CITY OF ALBUQUERQUE

Re: Ceja Vista Apartments/ PHASE 1
10001 Ceja Vista Rd. SW
Request for Certificate of Occupancy
Transportation Development Final Inspection
Architect's Stamp dated 11-25-19 (P09-D002G)
Certification dated 05-04-23

Based upon the information provided in your submittal received 05-11-23, Transportation Development cannot approve the release of Certificate of Occupancy for the above referenced project.

SDP1.1

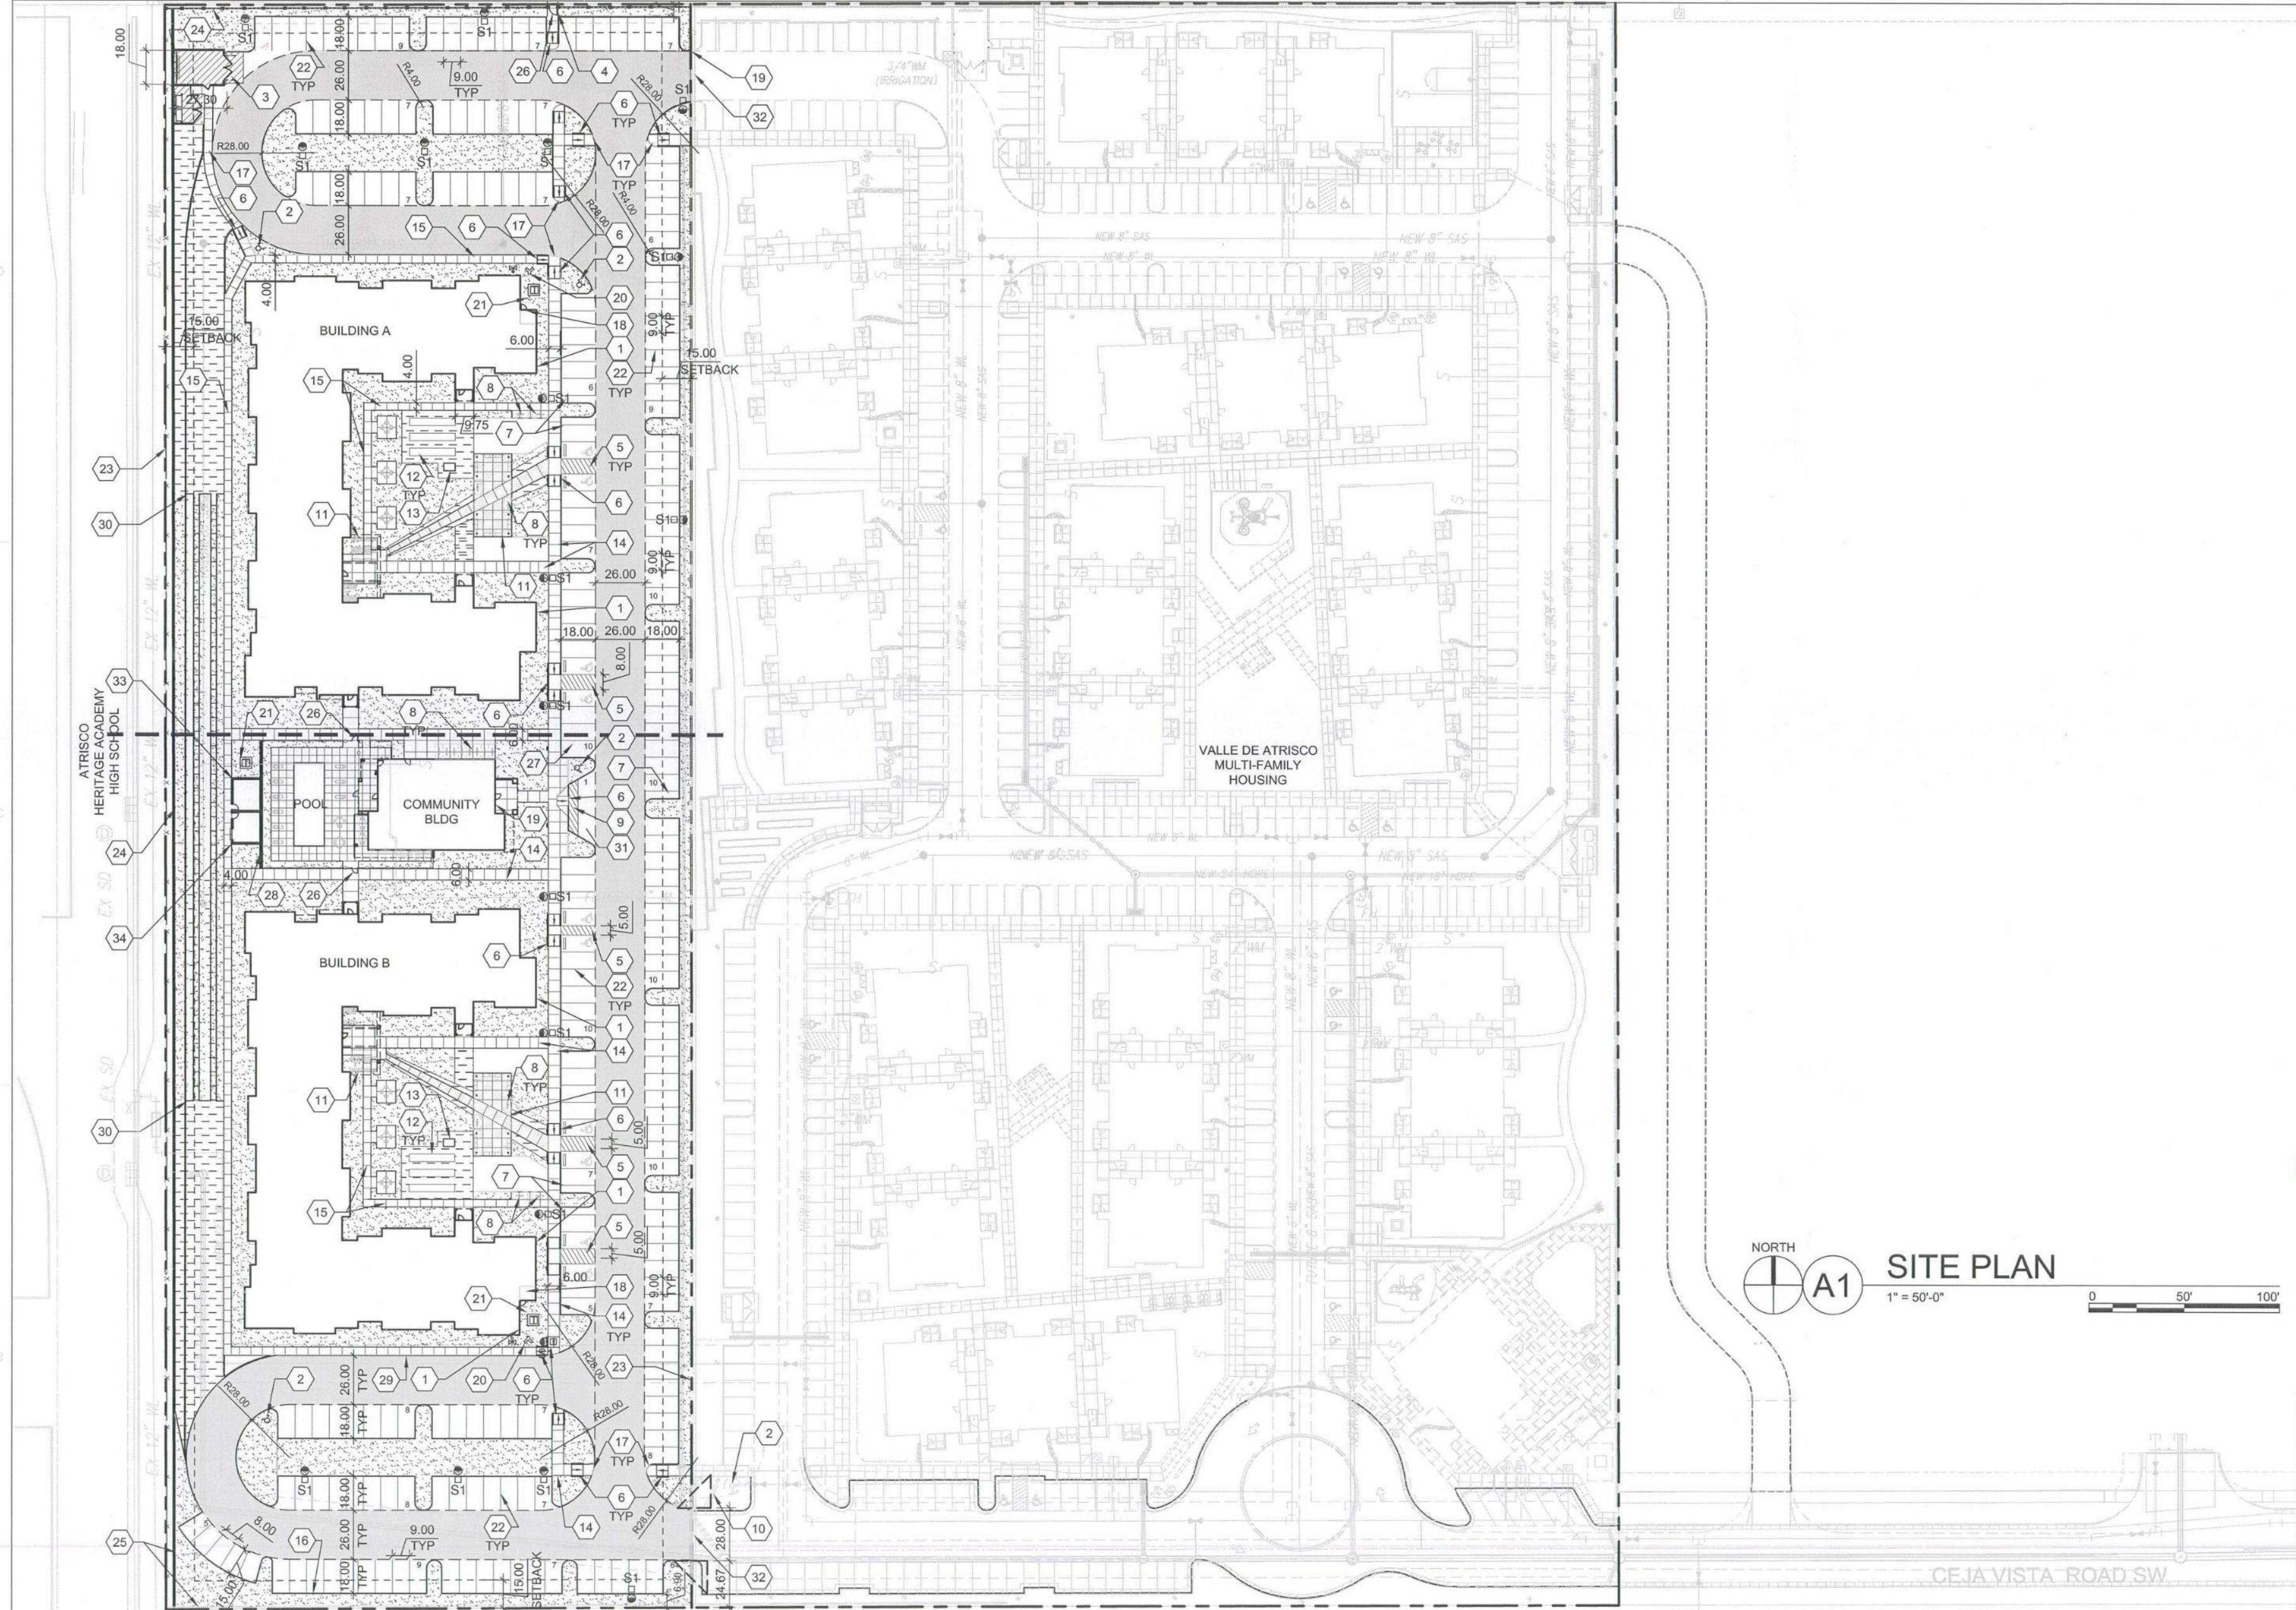
- Keynote 4: Per site visit pedestrian pathway from the north side Trail, is missing. And pedestrian gate is missing too.
- Per site visit, the width of the pathway at the west side of the Trash Enclosure is 3.5 ft. But the Approved site plan shows 5 ft. wide pathway. Please provide 5 ft. wide path way.

- Pathway striping at the east side of the Community Building is missing.
- Please install the Vanpool parking sign.
- Van accessible aisles should be 8ft wide.
